Subject: BR/126/19/DOC 65c gravits lane

I have now reviewed the further information submitted and have provided *comments* next to my original responses below.

LOCATION PLAN
65C GRAVITS LANE BOGNOR REGIS

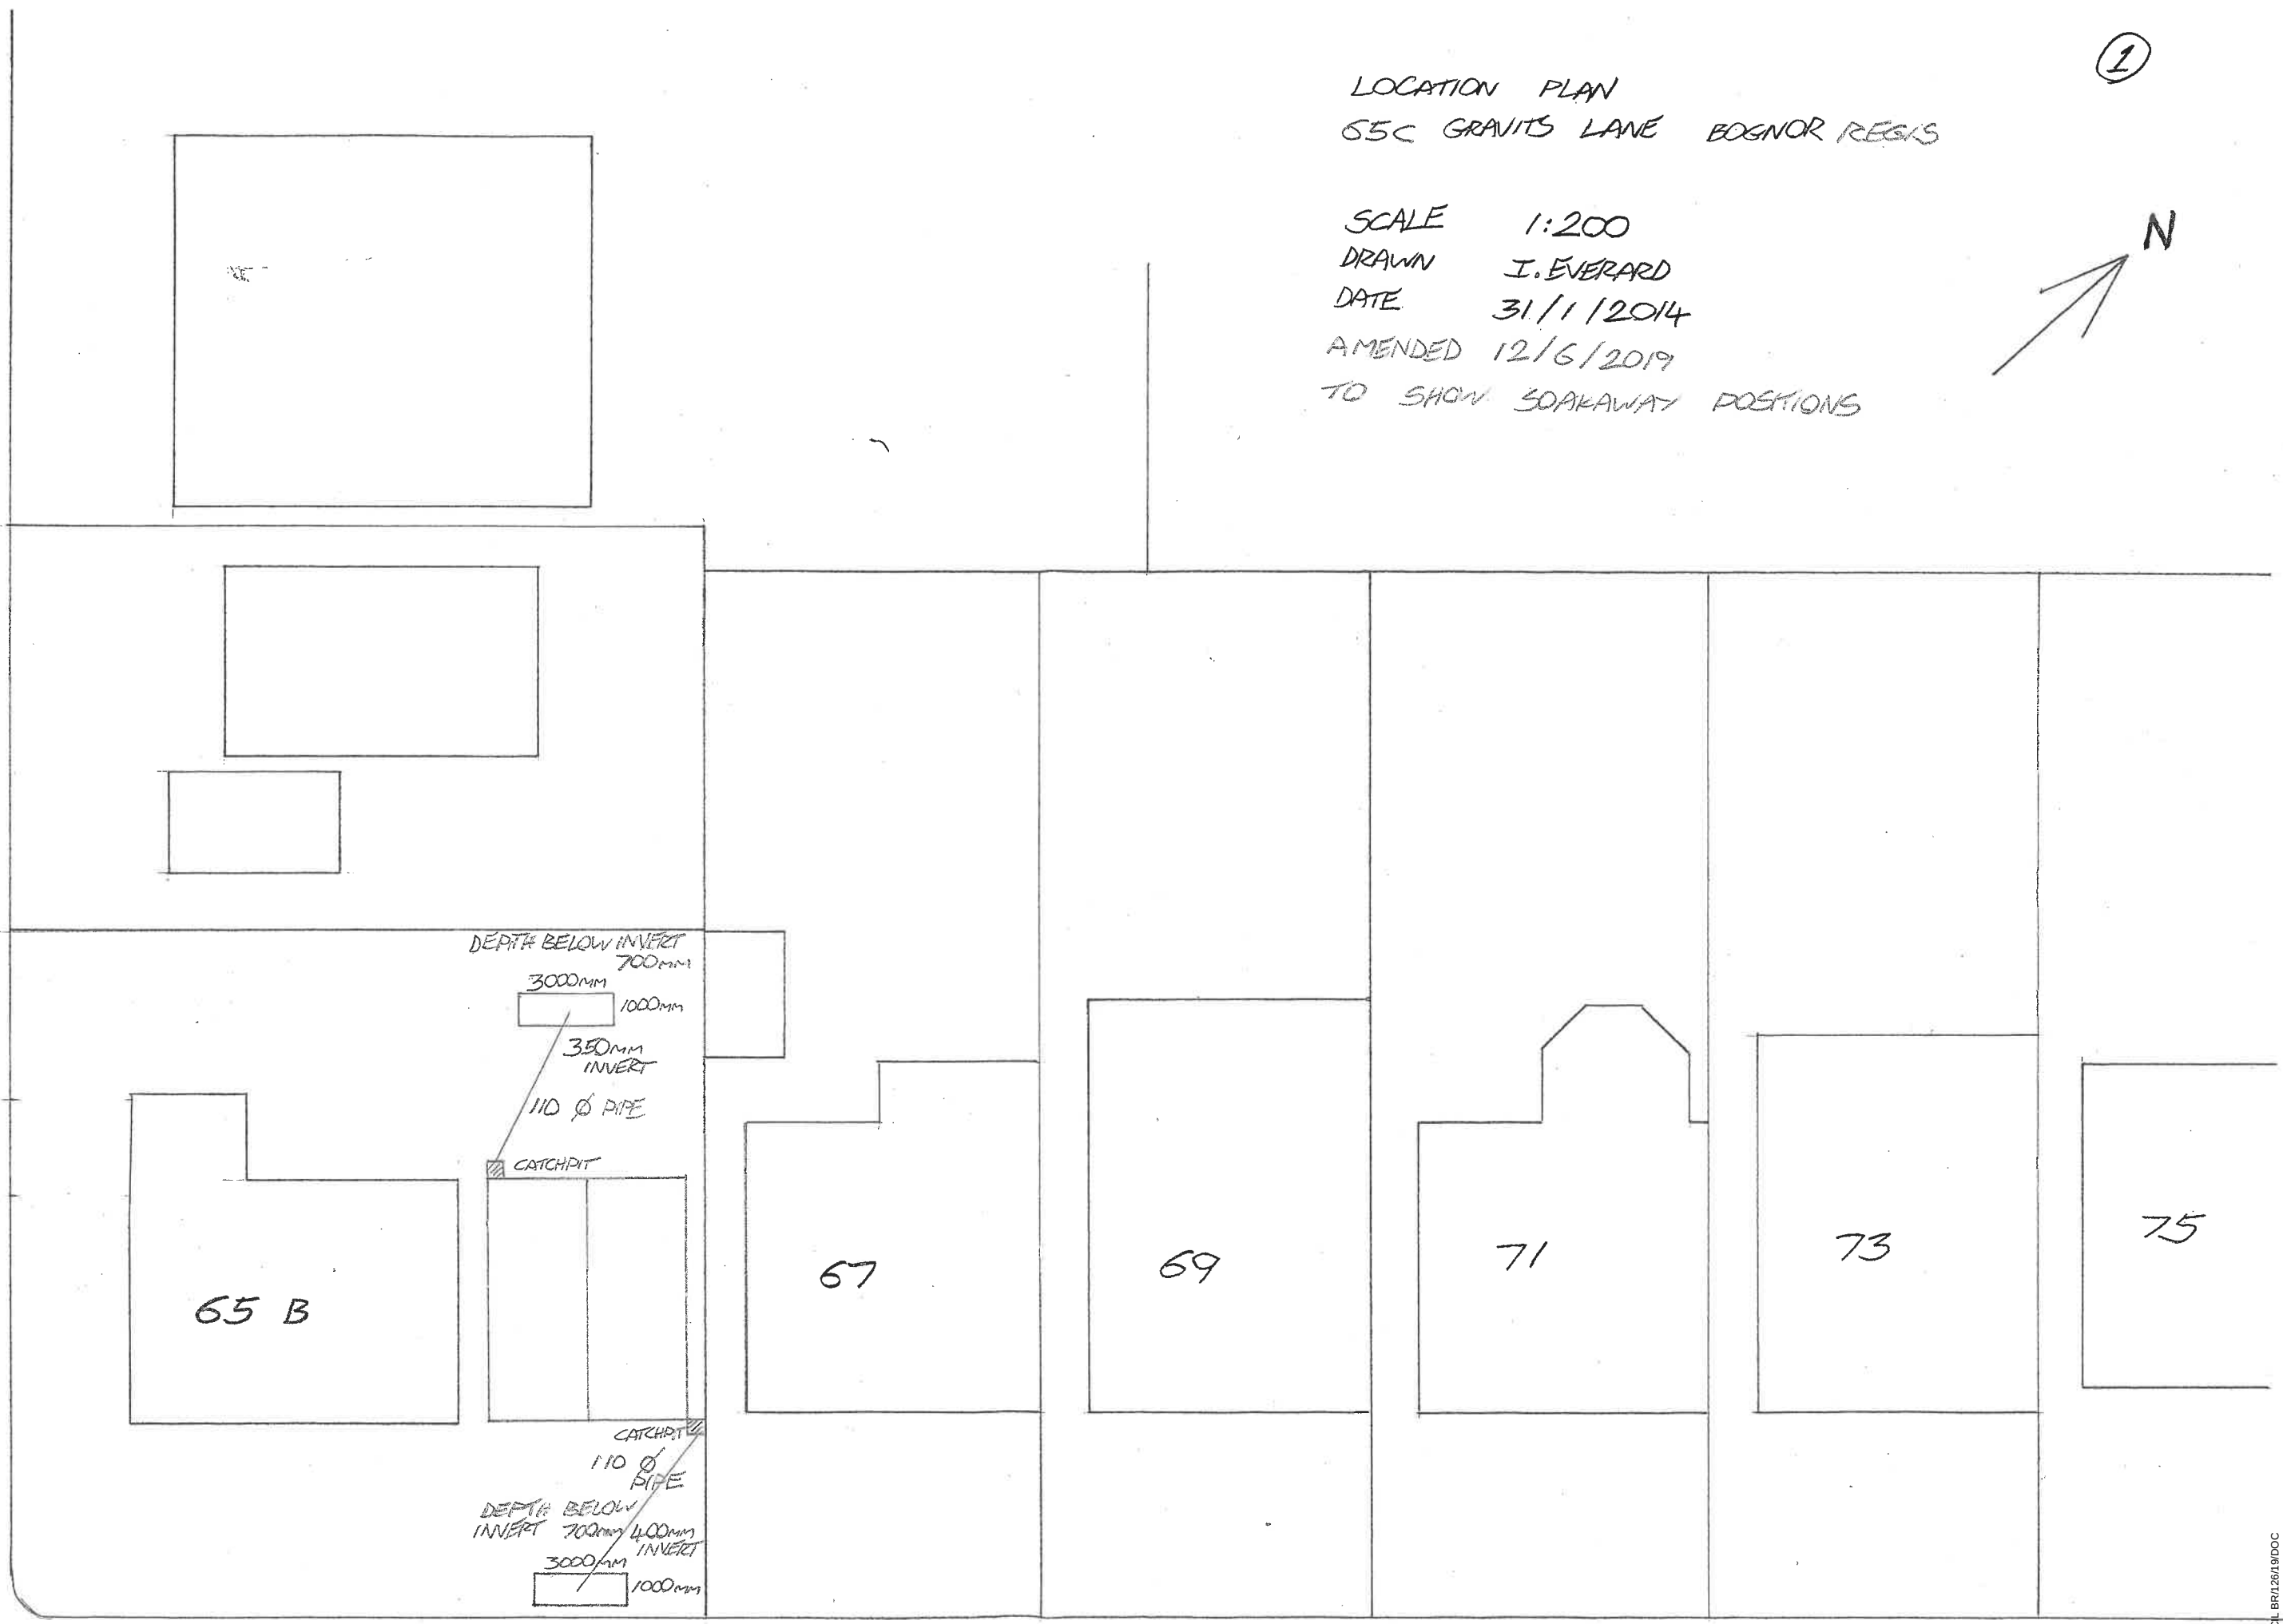
4. The drainage layout plan does not provide the level of detail which I requested on the 13th June. I.e. location and dimensions of pipes, catchpits and soakaways. Diameters, invert levels, cover levels and falls need to be provided. *Okay.*

FRONT AND REAR SOAKAWAY CONSTRUCTION
FOR G5C GRAVITY LANE BODNOR REG'S
W. SUSSEX

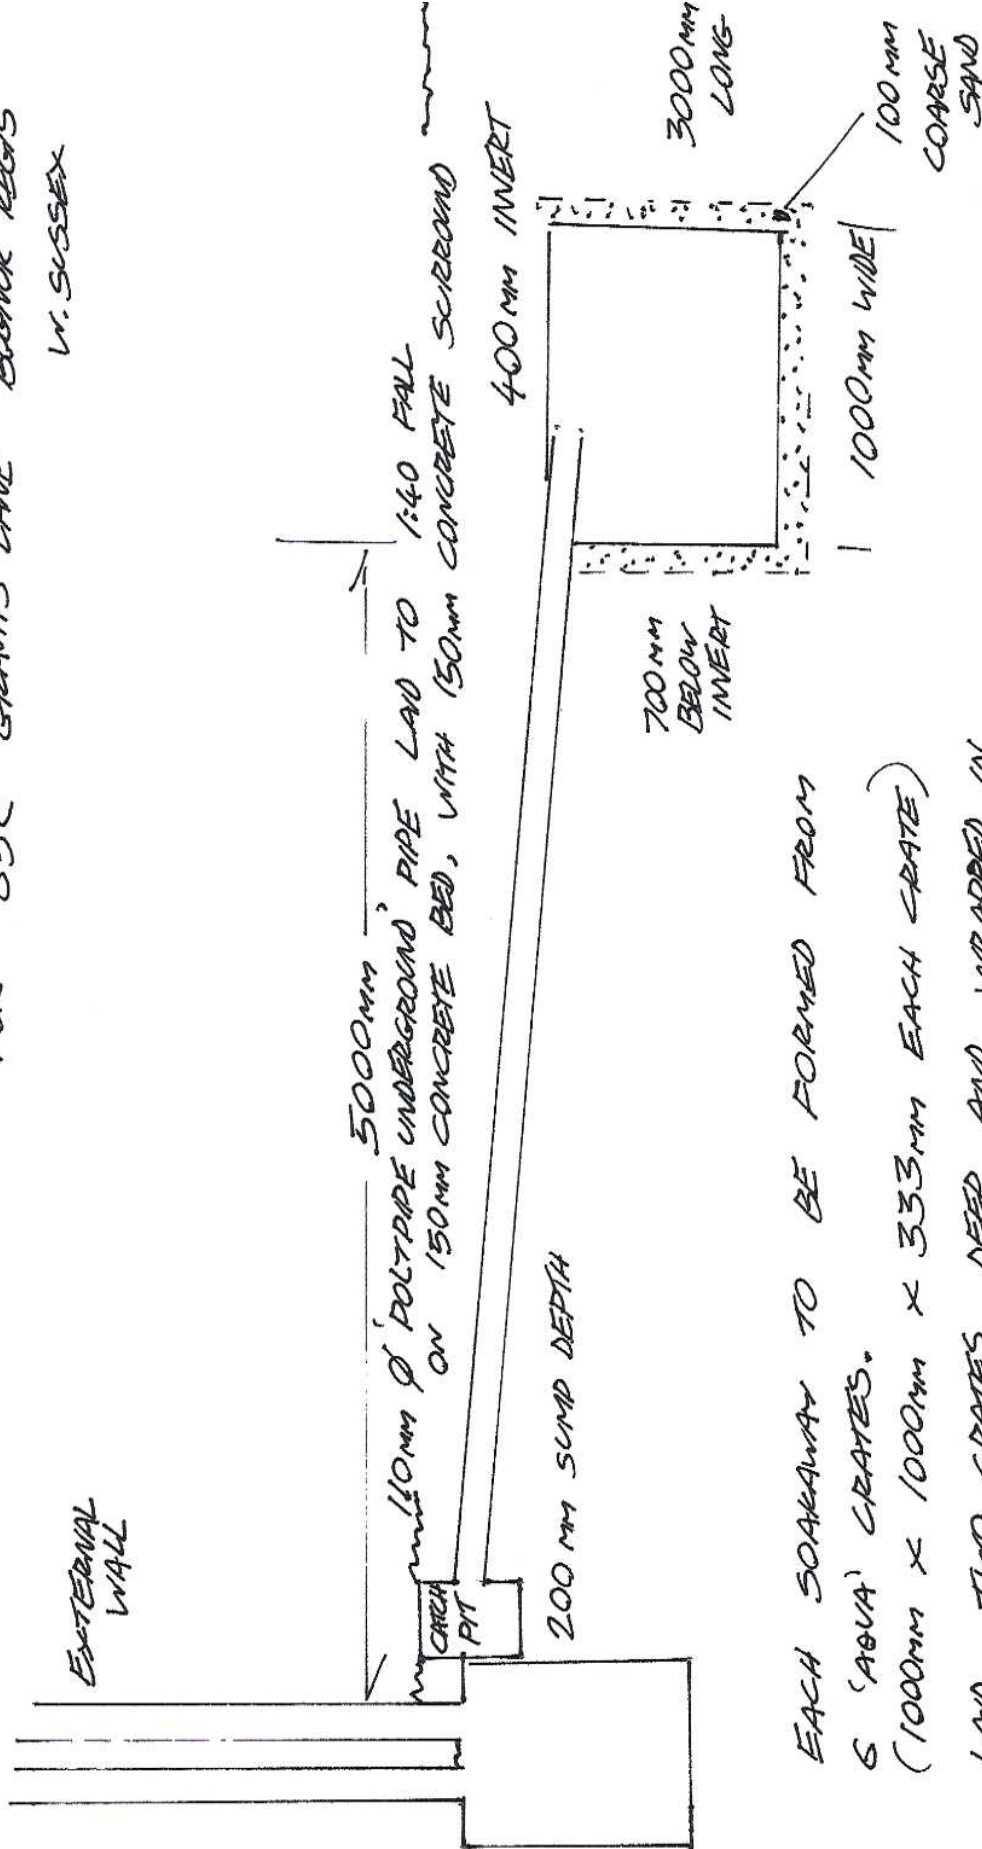
3. Construction details have not been provided. *The cross section detail drawing needs to be updated to state that the pipe will have 150mm concrete bed and surround rather than shingle. And 100mm coarse sand bed and surround needs to be provided to the crates (outside of the geotextile wrap).*

INFILTRATION CALC'S
LAND ADJACENT TO
65B GRAVITY LANE
BOGNOR REGIS

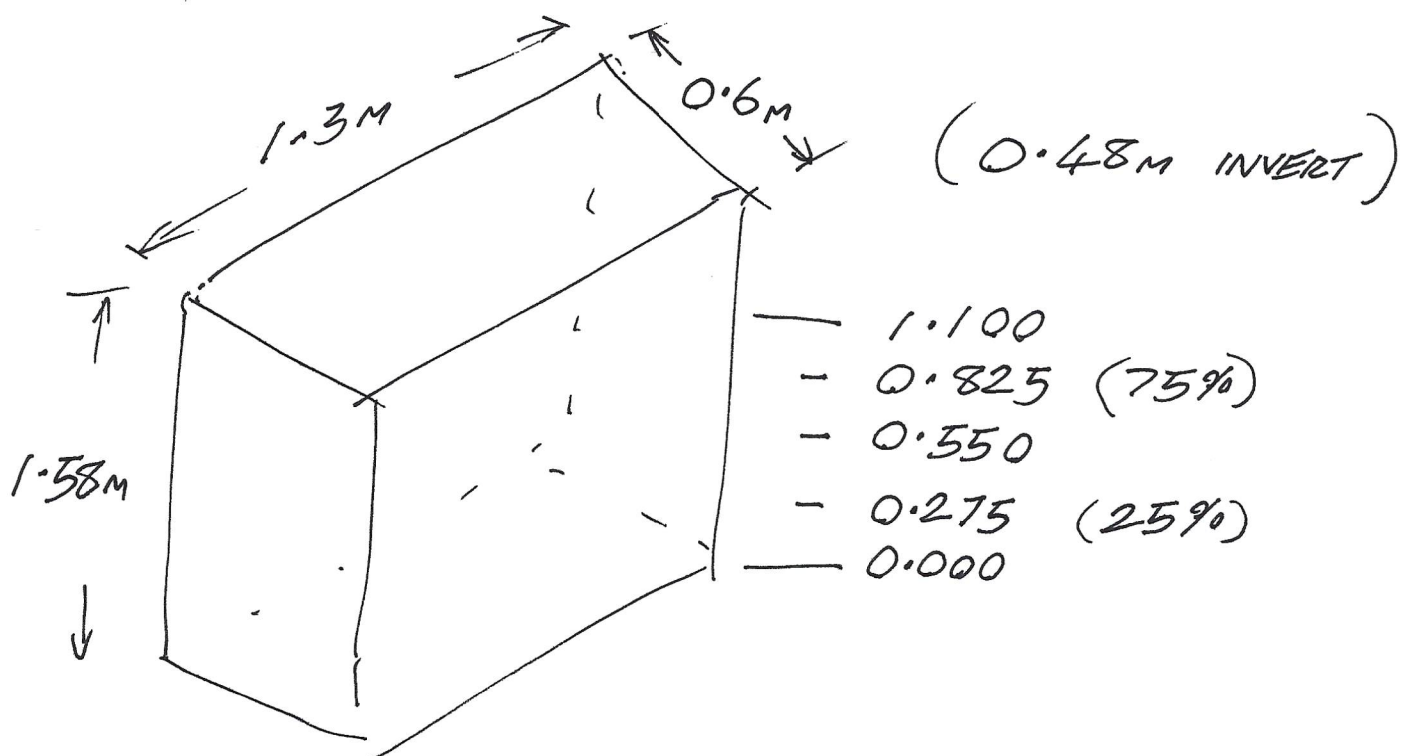
1. The applicant has supplied information regarding groundwater levels and infiltration test results. Both of these were from July 2014, subsequent observations were made and notes indicate no groundwater was observed. However, this does not meet our requirements for winter infiltration testing. *Winter infiltration date has been specified, but no actual test results have been supplied and it is unclear if three repeat tests were completed.*
